DECISION DELEGATED TO HEAD OF PLANNING

Application No: H17-1026-23 **Applicant:** Mr G Giessler

Proposal: Proposed open front store

Location: 5 Low Gate Surfleet Spalding

Front Elevation

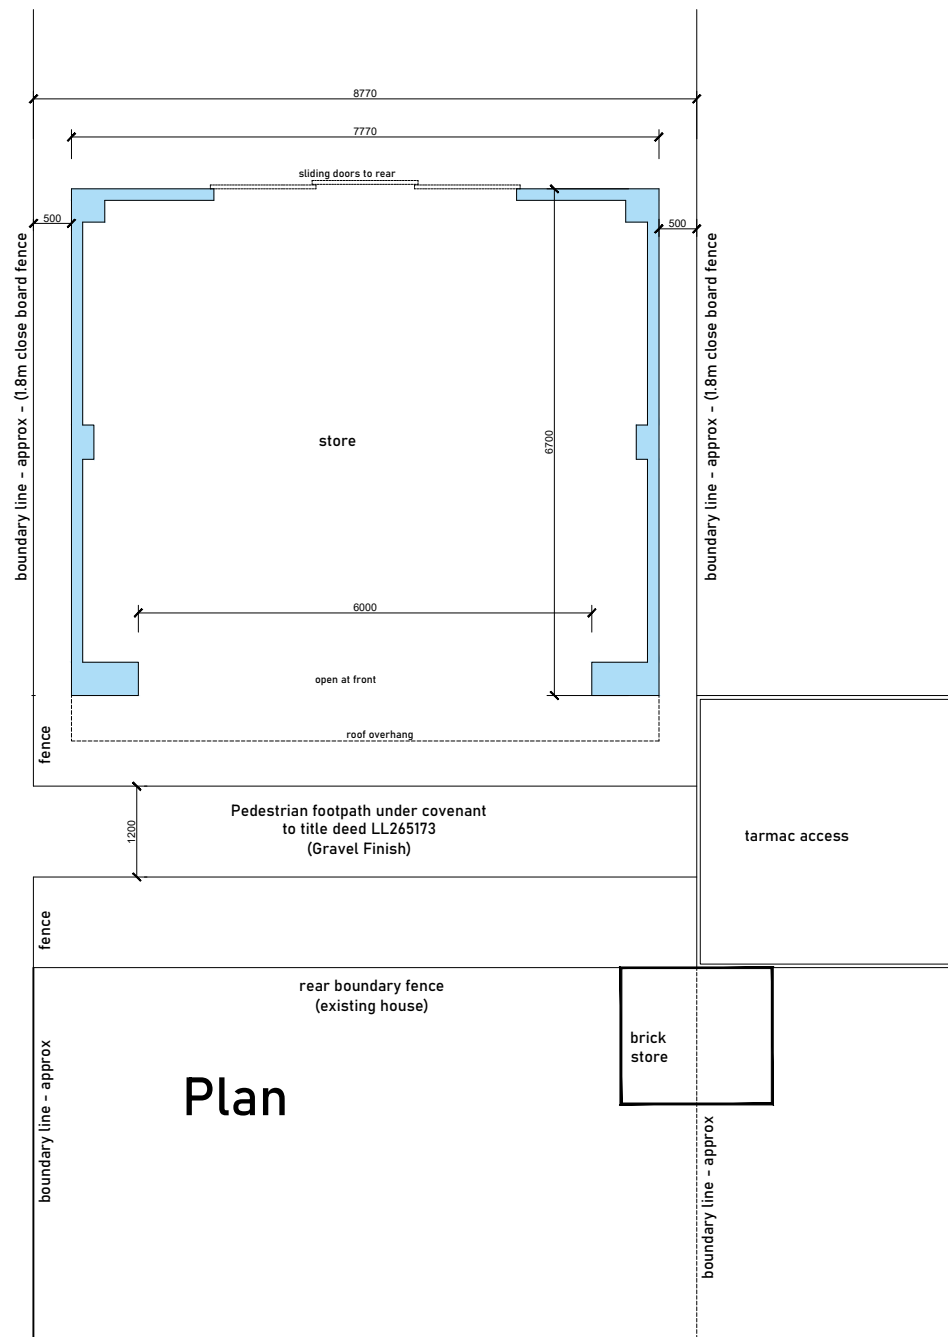
The store would measure 7700mm (width) by 6700mm (depth). The proposal would feature a dual pitched roof, with a maximum height of approximately 5500mm. A distance of 500mm to either boundary is proposed. The store would be constructed of concrete block, with timber cladding to the front. Concrete roof tiles are proposed.

The scale of the proposed outbuilding (detailed above) is substantial, and as such, the visual impacts arising from the proposal are considered to be substantial. This scale, coupled with the proximity to both the neighbouring boundaries and to the rear access path, would create an unduly dominant and harmful feature. When this visual impact is combined with the existing storage buildings, both on and adjacent to the site, the cumulative impact would become significant and harmful. This cumulative impact would result in the rear of Low Gate appearing almost industrial in nature, and severely at odds with the rural character of the area. As such, it is considered that the proposal fails to respond to the character of the area, and therefore, fails to embody the principles of good design outlined within Paragraphs 41, 42 and 53 of the National Design Guide.

The proposed use of exposed concrete block walls would be out of keeping with the character of the area. There is no precedent in the immediate area for this material, resulting in the proposal appearing incongruous. Due to the substantial scale of the development, the impacts of this unsuitable material would be exacerbated. Paragraph 57 of the National Design Guide states "Materials, construction details and planting are selected with care for their context. They are attractive but also practical, durable and affordable. They contribute to visual appeal and local distinctiveness". It is considered that the proposal fails to adhere to this point as the materials do not reflect local distinctiveness.

Plan

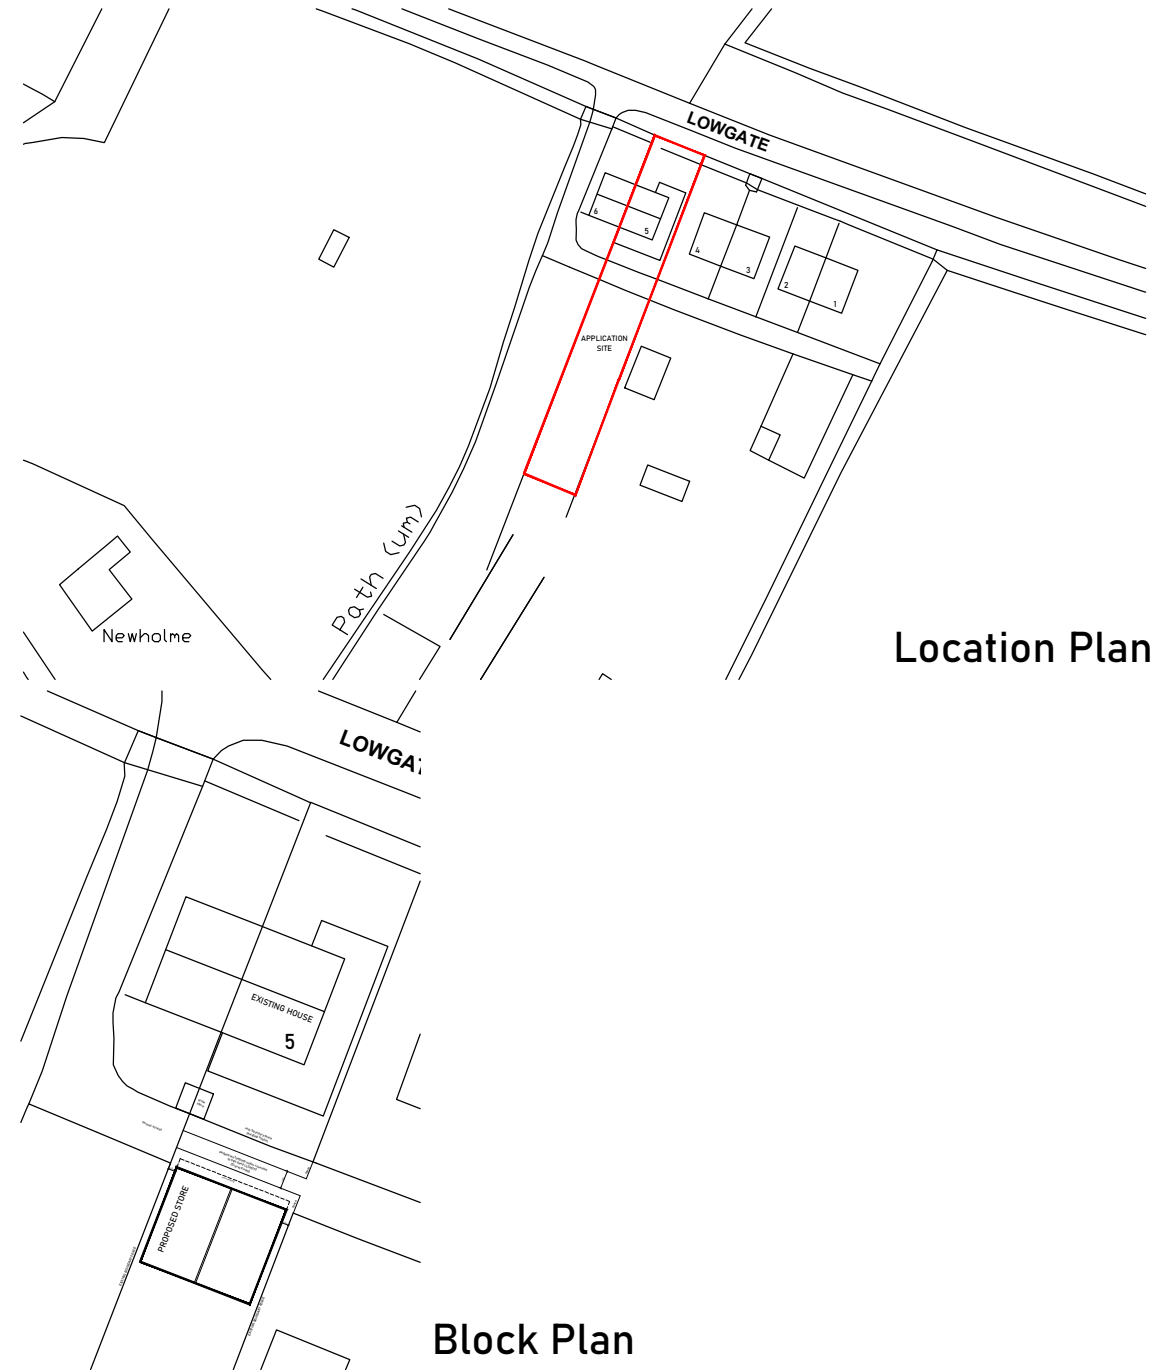
The proposal would not result in additional overshadowing to the east, with any potential overshadowing falling upon the large, windowless walls of 4 Low Gate's outbuilding. The proposal would result in a significant loss of light to the garden and driveway of 6 Low Gate, due to the minor distance to the boundary and the significant height of the proposed outbuilding. This may lead to a potential reduction in the quality of life of the occupants.

Several objections have been received stating that the proposal would restrict access and parking to neighbouring dwellings. The proposed fence would cut across the existing rear vehicle access, preventing access to 1-4 Low Gate, except for via foot. Objections have stated that this is in violation of an existing covenant which prevents tampering with this access. This is considered to be a civil matter, and as such, carries limited planning weight.
